City of Albuquerque Stormwater Construction Site Inspection Report

General Information					
ESC File No.	N09E014		Project Name:		Desert Sands
NPDES Id. No.	NMR1000BE		Location:		3000 98th St SW
4/13/2023	Owner		Contractor		
Operator	Salazar		LGI Homes		
Contact name & title	Eddie Loven		Greg Mayfield & Edddie Loven		
e-mail	Eloven@lgihomes.com		greg.mayfield@lgihomes.com		
Contact Phone #	991-0807		970-640-1786		
COA Inspector	Doug Hughes		Start/End Time:	3pm	
Construction Phase:	infrastructure complete				
Type of Inspection:	Regular	Storm Event	Post Storm Event >0.25"	311/Complaint	Follow Up
Weather at time of inspection?		Cloudy		Temperature: ~	80
Estimated date of last storm 0.25" or greater		3/16/2023

Erosion Sediment Control Plan

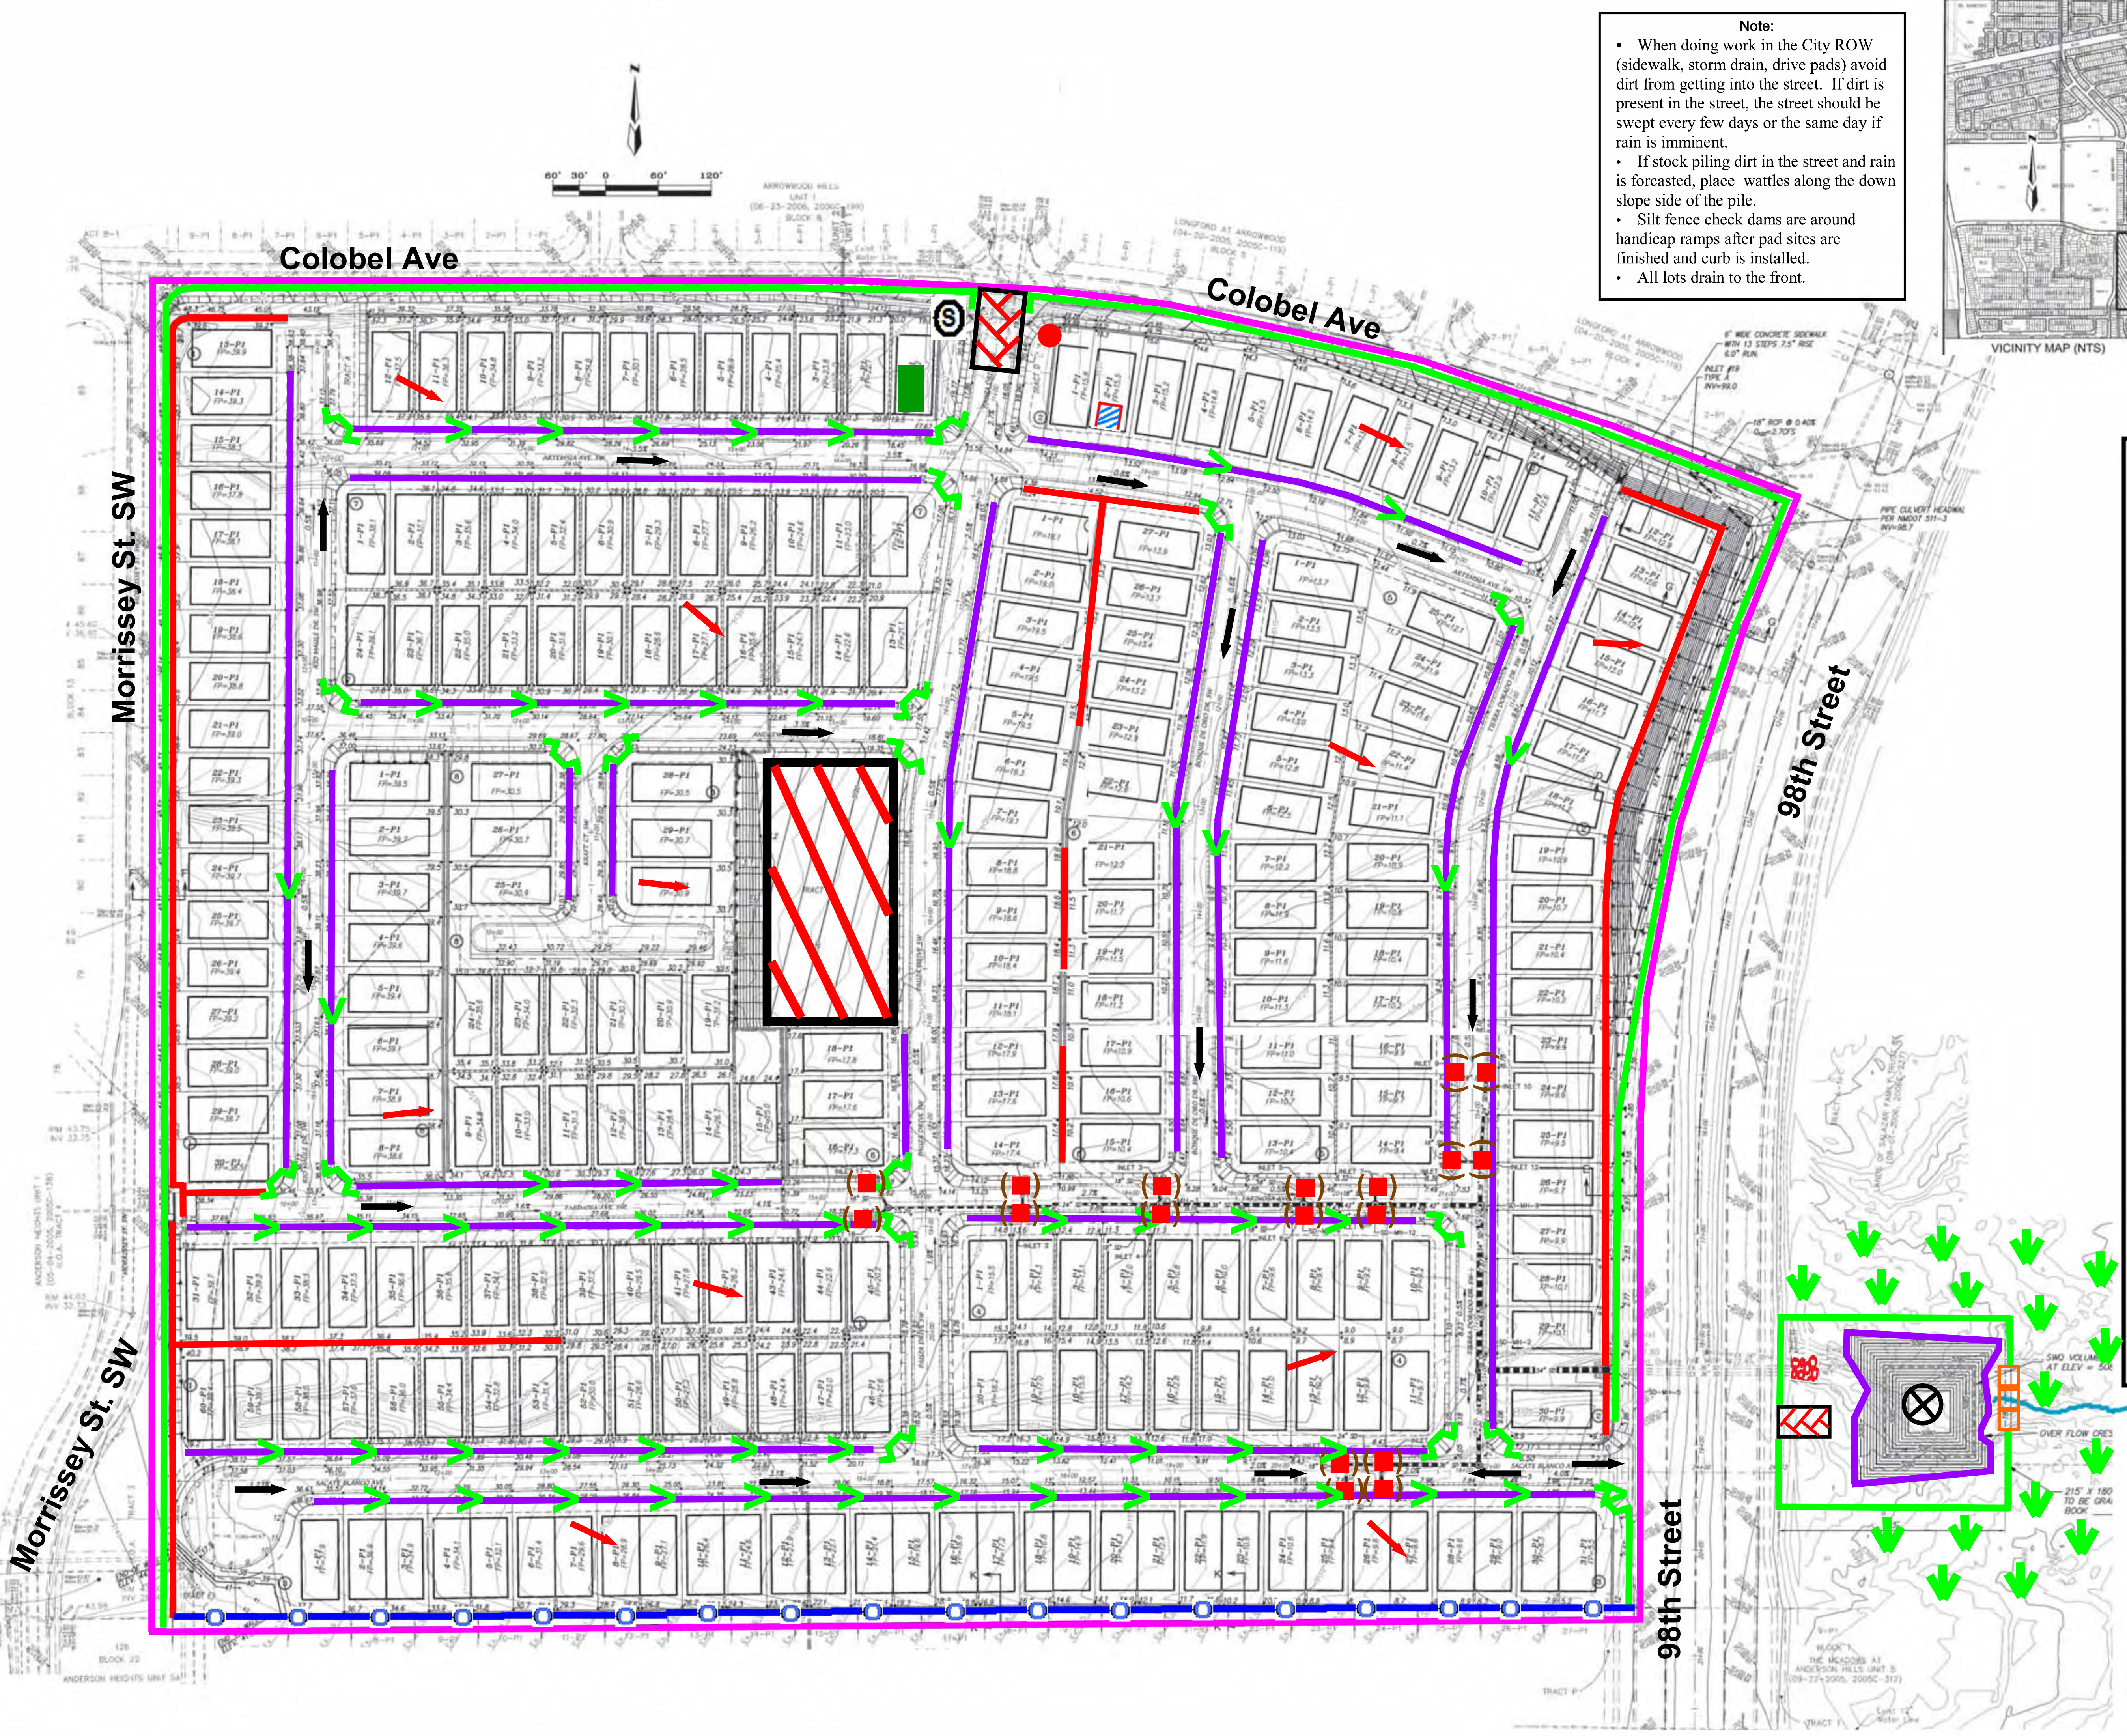
4	Increased flows from the Desert Sands development are causing streambank erosion at the discharge point on the neighbor's property in violation of CGP 2.2.11. Rip Rap there has failed twice now. You must repair the erosion and replace the rip-rap.				
5	Silt fence is missing. Please construct silt fence as barrier to protect seed unless stabilized immediately				
6	<p>The SWPPP and self-inspection reports were not available on site and there wasn't any sign posted to provide the plan's location. You must keep the SWPPP including Self Inspection Reports and Corrective Action Reports up-to-date per CGP 7.1 and available on-site per CGP 4.7.3, 5.4.3 and 7.3. If an on-site location is unavailable to keep the SWPPP when no personnel are present, you must post notice of the plan's location near the main entrance of your construction site per CGP 7.3.</p> <p>At a minimum a routine compliance self-inspection is required to review the project for compliance with the Construction General Permit once every 14 days and after any precipitation event of 1/4 inch or greater until the site construction has been completed and the site determined as stabilized by the city.</p> <p>After all areas have been stabilized, you must contact the City for verification that the "Final Stabilization Criteria" of CGP 2.2.14.c has been satisfied. This step is independent of the Certificate of Occupancy (CO) process. Then satisfy the other "Conditions for Terminating CGP Coverage" per CGP 8.2 including removal of BMPs. Next, file your "Notice of Termination" (NOT) with the EPA. Please copy me with the documentation and the EPA's acceptance of the NOT.</p>
